# CITY OF ALBUQUERQUE

March 16, 2023

**RE: Golf Course & Westside Commercial Development  
Grading & Drainage Plans and Drainage Report  
Engineer's Stamp Date: 02/15/23  
Hydrology File: A12D008B2**

SHEET #
C2

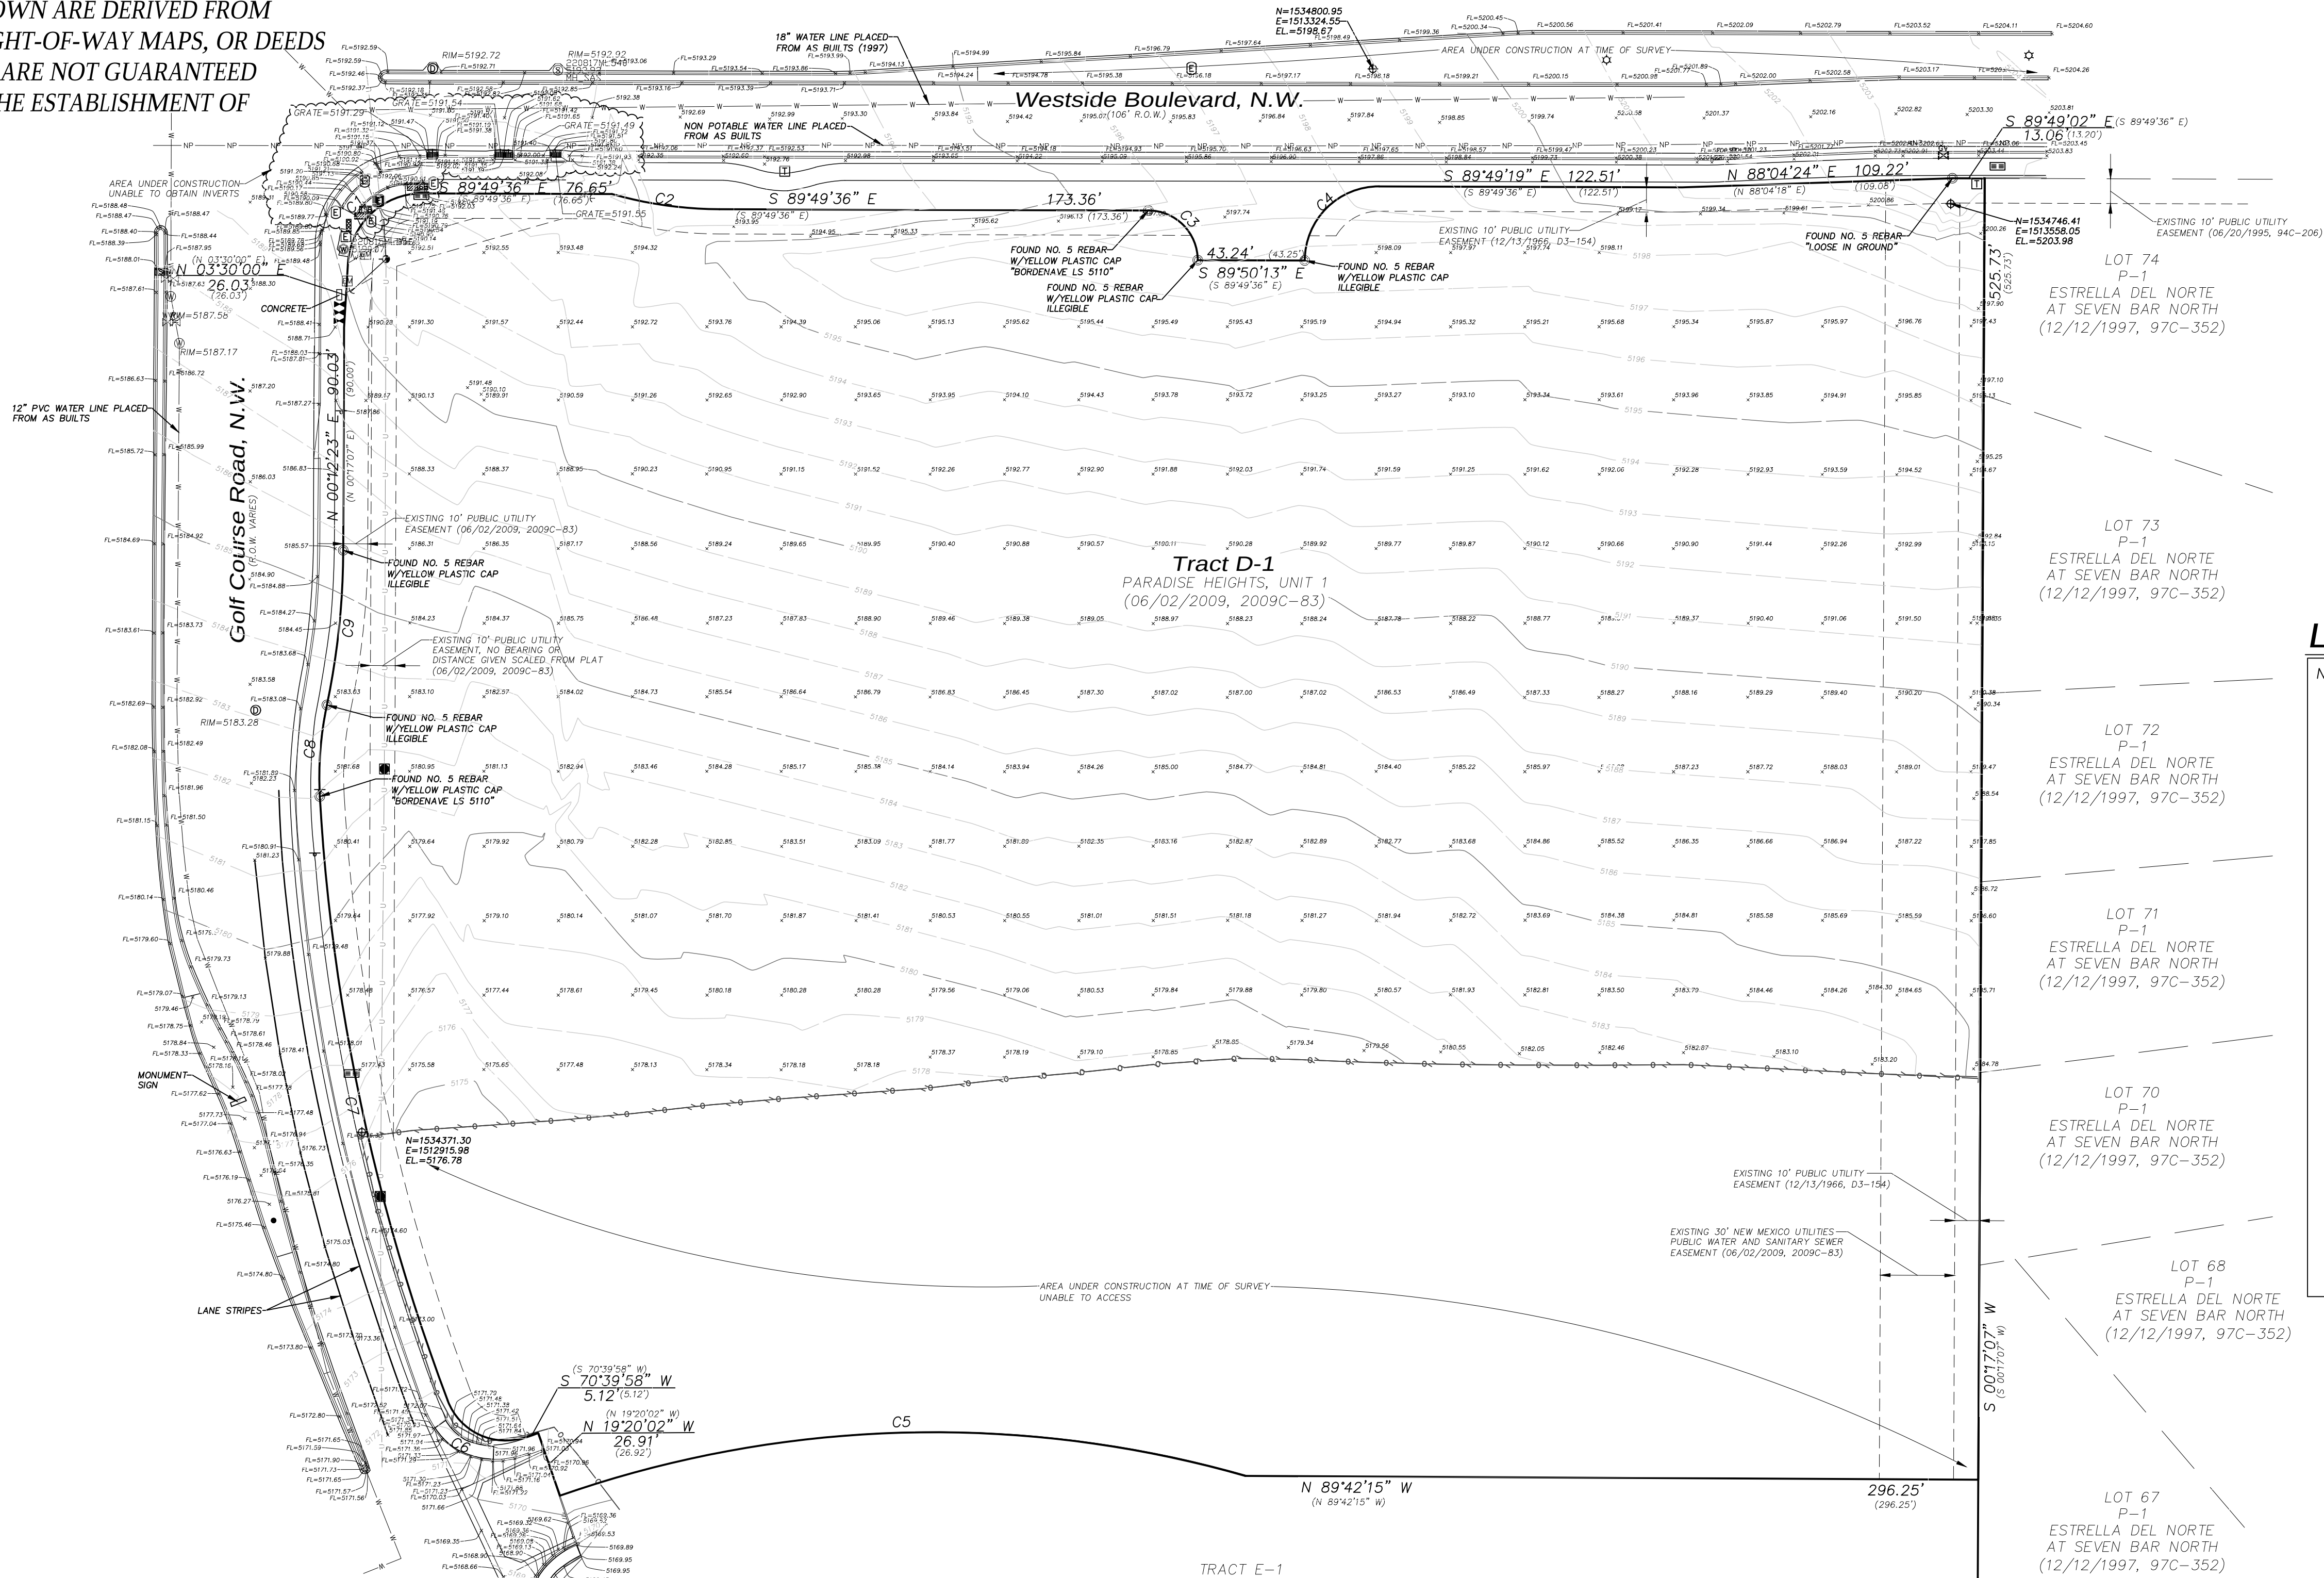
6. All the storm drain within the development is private. There are call outs for HDPE and then there are call outs for RCP. Since this is all private storm sewer, please stick with only one material type.

7. All stub outs should be only 5 feet beyond the proposed sidewalk and should have a plug with an inv elevation.

8. Depending on the material that is to be used, please fix the stub out connections. If RCP is to be used, then you will need manholes for the connections. If you use HDPE, then that is not needed since they do make Tee connections. If HDPE is to be used, please ensure that the tee connections are at least 5 feet from all manholes and inlets for buildability.

**CMP RISER DETAIL**  
NTS

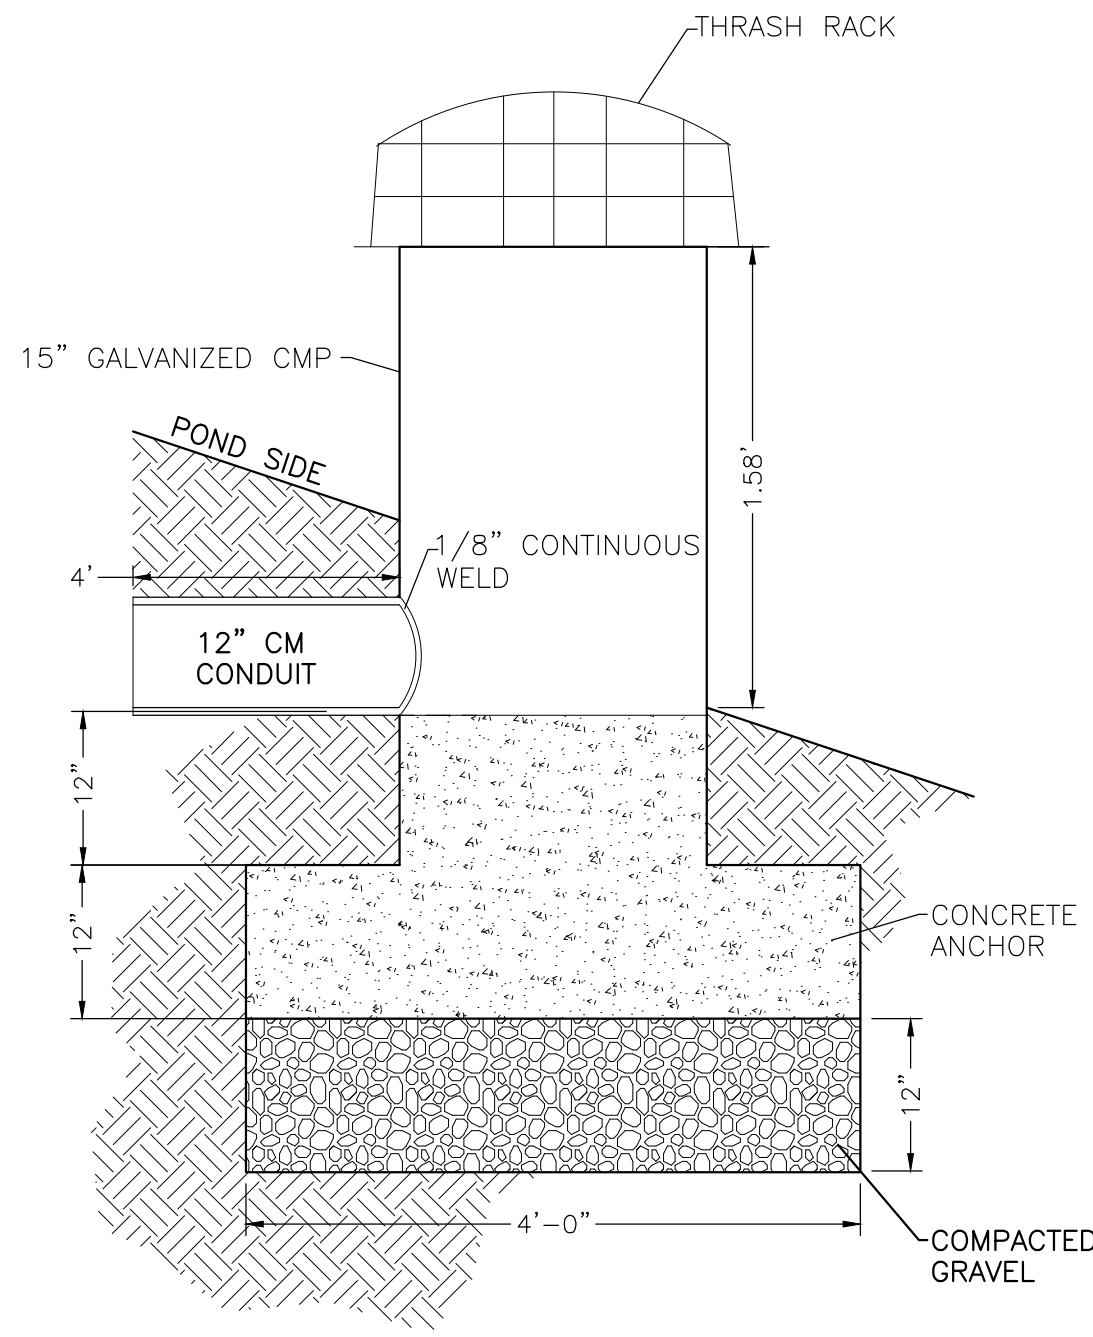
9. The proposed stand pipe will not function as shown. It needs to be at the bottom of the detention pond in order to work since the 1" dia holes will be drilled 360 degrees around the pipe. Also, the detail has information missing in order to build it as designed.
